## Inspector's Report ABP-315789-23

<b>Question</b>	Whether the widening and alteration of a gateway, is or is not development and is or is not exempted development.
<b>Location</b>	Darrynane More, Caherdaniel, Co. Kerry.
<b>Declaration</b>	
Planning Authority	Kerry County Council.
Planning Authority Reg. Ref.	EX 1045.
Applicant for Declaration	John Cox.
Planning Authority Decision	Is not exempted development.
<b>Referral</b>	
<b>Referred by</b>	John Cox.
<b>Owner/ Occupier</b>	John Cox.
<b>Observer(s)</b>	None.
<b>Date of Site Inspection</b>	14 February 2024.
<b>Inspector</b>	Daire McDevitt.

*Is the widening of a gateway exempted development?*

ENTRANCE
BEFORE
STORM
DAMAGE

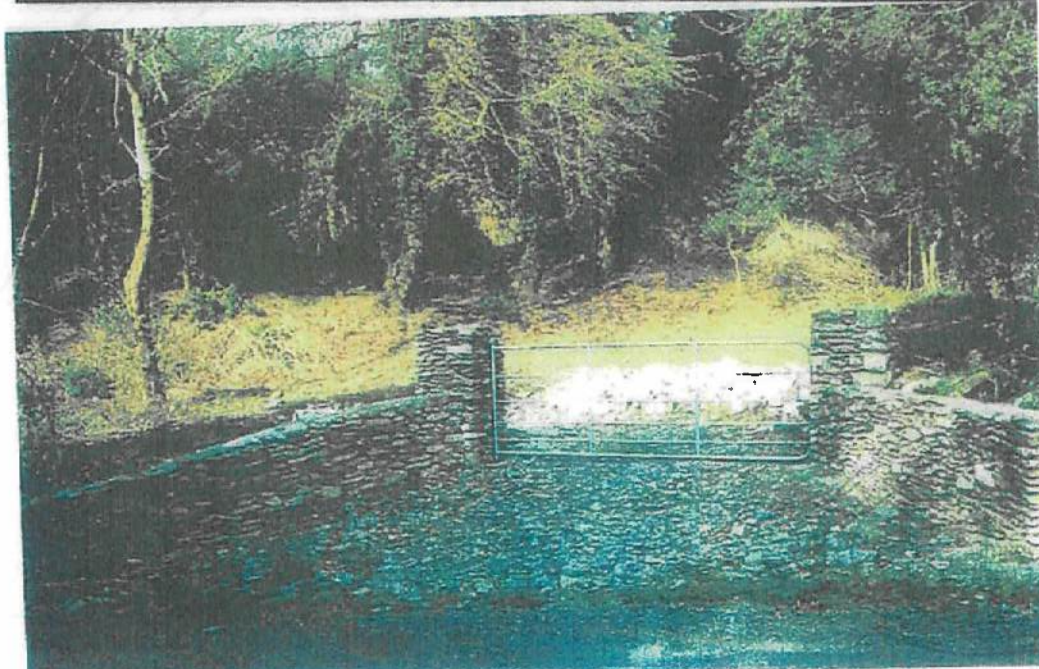
Based on available information there is evidence to suggest an entrance was in place since 2009 (see google images). The owner has submitted that the entrance has been in place for over 20 years, I have no evidence of same. Furthermore the

entrance visible of the images from 2009 refer to what resembles an agricultural gate which served as access to an overgrown/wooded area. I have no evidence before me that this access was used by vehicles prior to the widening and alterations. I note tracks on the land at the time of my inspection and can therefore deduce that vehicles have accessed the land via this entrance (gateway). I also note from the planning history associated with the site that 2 mobile homes were placed on the lands but have since been removed.

The development would endanger public safety by reason of traffic hazard or obstruction of road users. The development is located south of the junction with the Caherdaniel to Waterville Road with limited sightlines due to the vertical and horizontal alignment of the road at this point.
